Your ref:	147-149 Wardour Street	Please reply to:	Mr Anthony Perera
Our ref:	24/00628/FULL	Tel No:	07866034072
		Fee Queries:	0207 641 6500;
		Email:	planningreception@westminster.gov.uk;
Mr Susumu Shioya EDO Design & Construction Ltd. Unit D1B Up Bounds Green Industrial Estate Ringway London N11 2UD United Kingdom		Incomplete Applications Town Planning & Building Control City of Westminster PO Box 732 Redhill, RH1 9FL	
		20 February 2024

Address: 147 - 149 Wardour Street, London, W1F 8WD,

Proposal: Installation of a new shopfront.

Thank you for your recent response to our email dated 5 February 2024 requesting further information in respect of your application received on 31 January 2024. Regrettably I am writing to inform you that your application is still incomplete for the following reason(s):

DRAWING TITLE
Proposed External Elevation

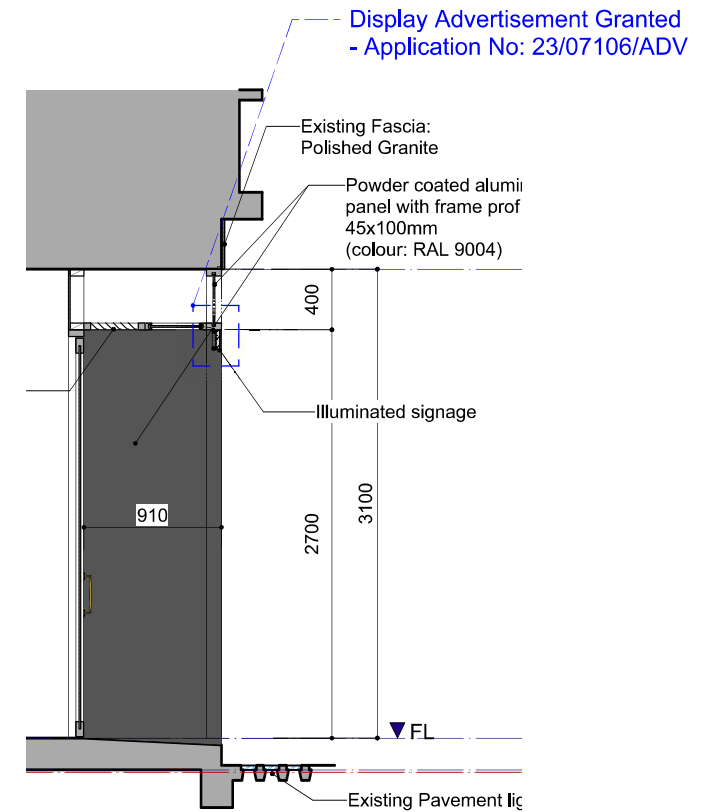
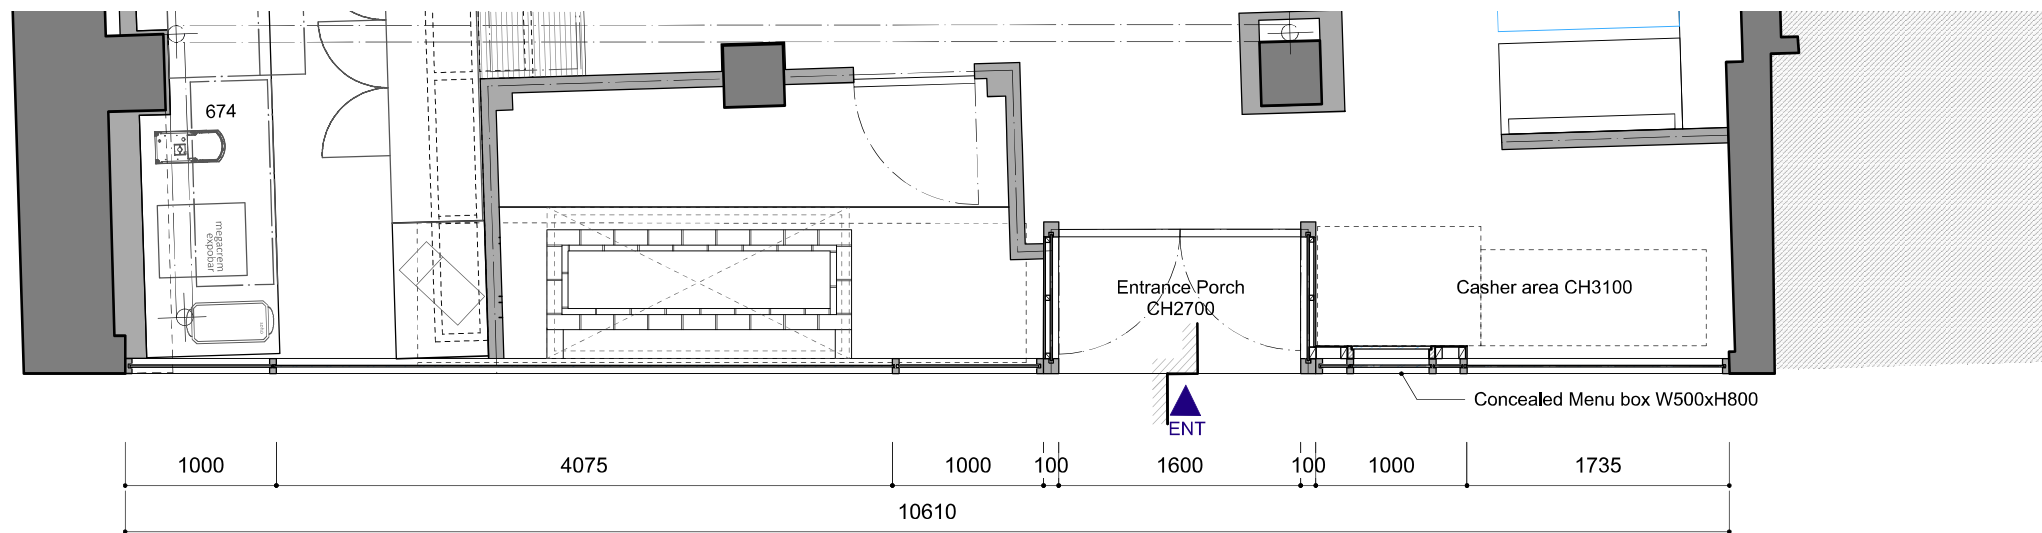
1 - It is not clear if the louvers are connected to any plant. Please can you confirm, however if so you will need to provide a noise report accordingly.
